DECISION DELEGATED TO HEAD OF PLANNING

Application No: H16-0653-23 **Applicant:** API Ltd

Proposal: Change of use from house in multiple occupation to two flats - Retrospective

Location: 136 Roman Bank Spalding

JOB TITLE : 136 Roman Bank, Spalding PE11 2HR	
DWG TITLE : As Built Plans	
DWG. NO. : 641-02-B	
SCALE : As shown @ A3 Do not scale from drawing	
DATE : 01/08/2023	
STATUS : PLANNING	
DRAWN BY : AK	CHECKED BY : NF
© CLAYTON ARCHITECTURE LIMITED. Tel: 01435 589485 E: info@claytonarchitecture.co.uk

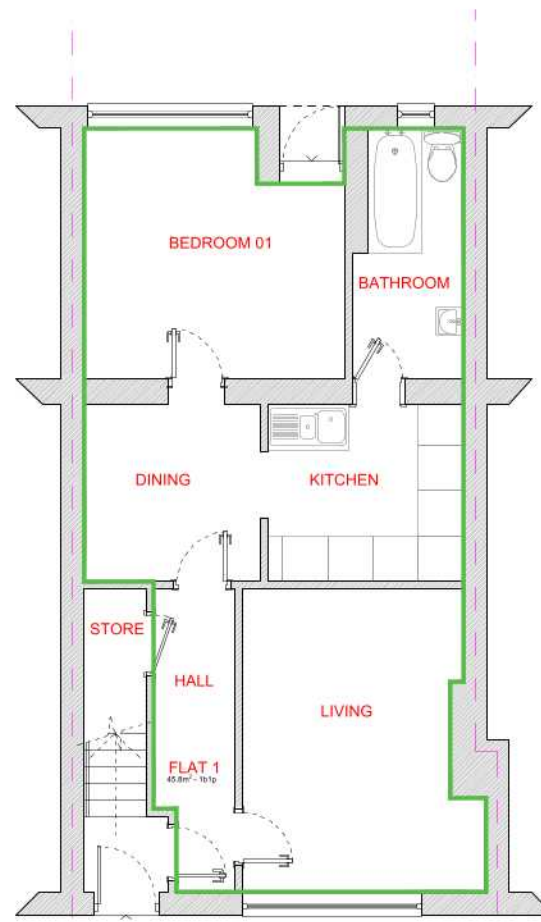
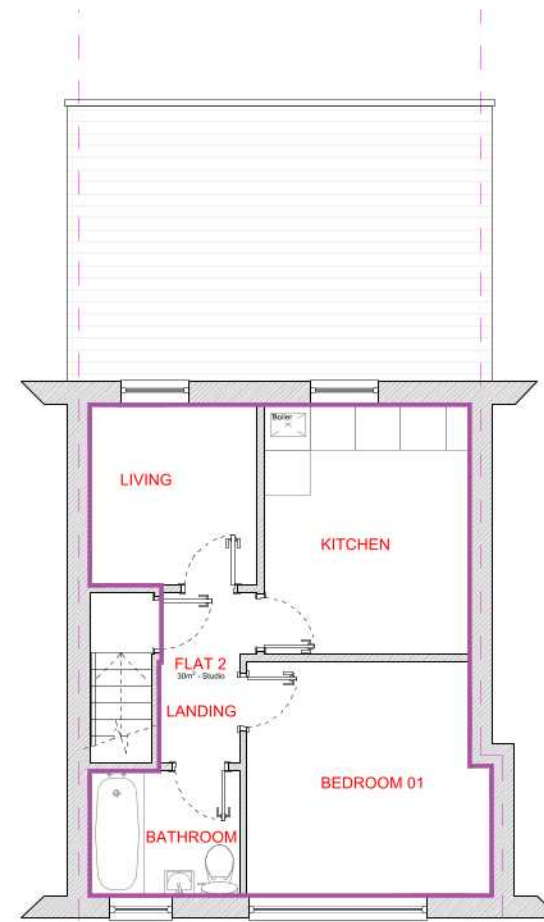
Two flats have been created: a ground-floor, single bedroom flat with a floor space of 46sqm; and a first-floor, one-bedroom flat with a space of 31sqm. While the plans refer to unit 2 as a studio flat, it is considered that the proposal fails to conform to the definition of a studio flat, and as such, is to be treated as a one bedroom dwelling.

The proposed ground floor flat is contrary to the Environment Agency's standard advice matrix. It would be extremely vulnerable to the adverse impacts of flooding and place residents at undue risk of harm. The potential negative impacts are exacerbated by the lack of refuge available to residents. If the property was a dwellinghouse, or its previous use as an HMO, then residents would be able to access the first floor of the property to seek refuge in the event of flooding, this is not possible as a ground floor flat.

As such, it is considered that the ground floor accommodation is unsuitable in this location. The potential flood depths of up to 2 metres would overtop any mountable flood defence and as no resilience measures are proposed, the occupants would be vulnerable to the economic and emotional costs of flood damage. The occupants would not have access to a safe refuge, putting them, and their belongings, at undue risk of harm even if a FWEP was in place. Therefore, the proposal fails to conform to Policy 4 of the SELLP as well as Section 14 of the NPPF.

Flat 1 has an internal floorspace of approximately 46sqm. The NDSS requires a gross internal floor space of 39sqm. The bedroom measures 10sqm and therefore achieves the required 7.5sqm. Flat 1 achieves the requirements of the NDSS.

Flat 2 has an internal floorspace of approximately 31sqm. The NDSS requires a minimum of 39sqm. The proposal substantially falls short of this requirement.

The proposal would result in the loss of a family sized dwelling, there is a lack of amenity space, and the proposal dramatically falls short of the required space standards under the NDSS. As such, it is considered that the proposal fails to conform to Policy 21 of the SELLP and the sub-division of the dwelling is unacceptable. In failing to meet these requirements, the proposal also fails to achieve the aims of Policies 2 and 3 of the SELLP as well as Section 12 of the NPPF, all of which seek to create high quality amenity and good living conditions.
